Subject: 65-71 Upper Bognor Road Bognor Regis PO21 1HR - BR/253/21/L

Planning Application Reference: BR/253/21/L

Proposal: Listed building consent for alterations to four listed buildings involving insertion of new windows, insertion of a new staircase, repairs and reinforcement of existing timber floors and roofs, removal of internal walls, forming openings in existing internal walls, erection of new internal partitions; extension of a listed building to create an office and warden's accommodation; erection of new building consisting of 3 No. flats, offices and workshops; creation of new private gardens, separation of this part of the site from the wider University campus, creation of a shared landscaped courtyard, creation of areas for parking and storage for bins and cycles.

7 Parking

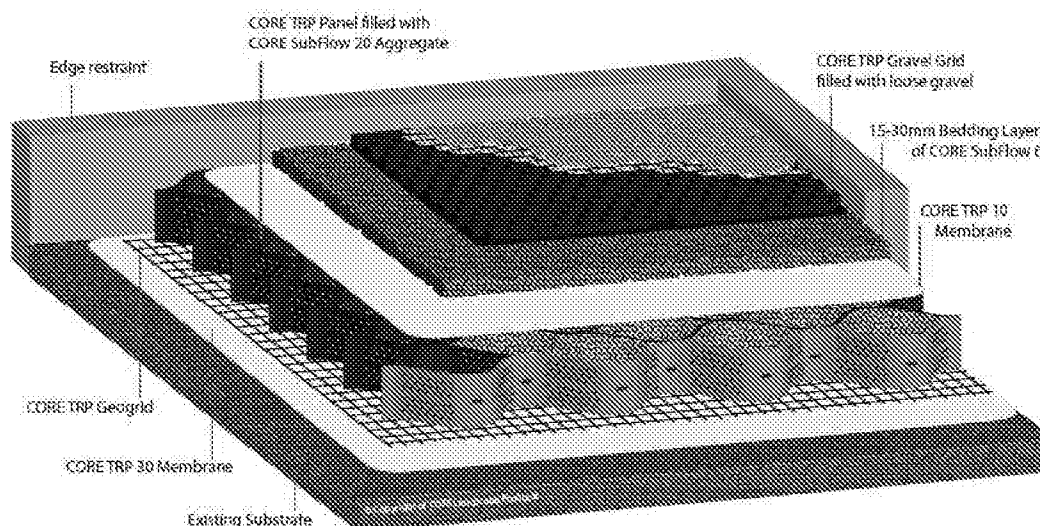
** I note from 'proposed site plan 5557-100-D7' that 4 EVCPs have been included. In accordance with recent government guidance, any new residential dwellings (or existing dwellings undergoing major

refurbishment) with dedicated parking must have 1 EVCP per dwelling. For new non-residential buildings (or existing buildings undergoing major refurbishment), every 1 in 5 parking spaces must include a EVCP.

Prior to occupation of any of the dwellings or first use of the commercial units, a scheme for the provision of facilities to enable the charging of electric vehicles to serve the approved development shall be submitted to the local planning authority for approval and thereafter implemented in accordance with the approved details and the charge points shall thereafter be retained and maintained in good working condition.
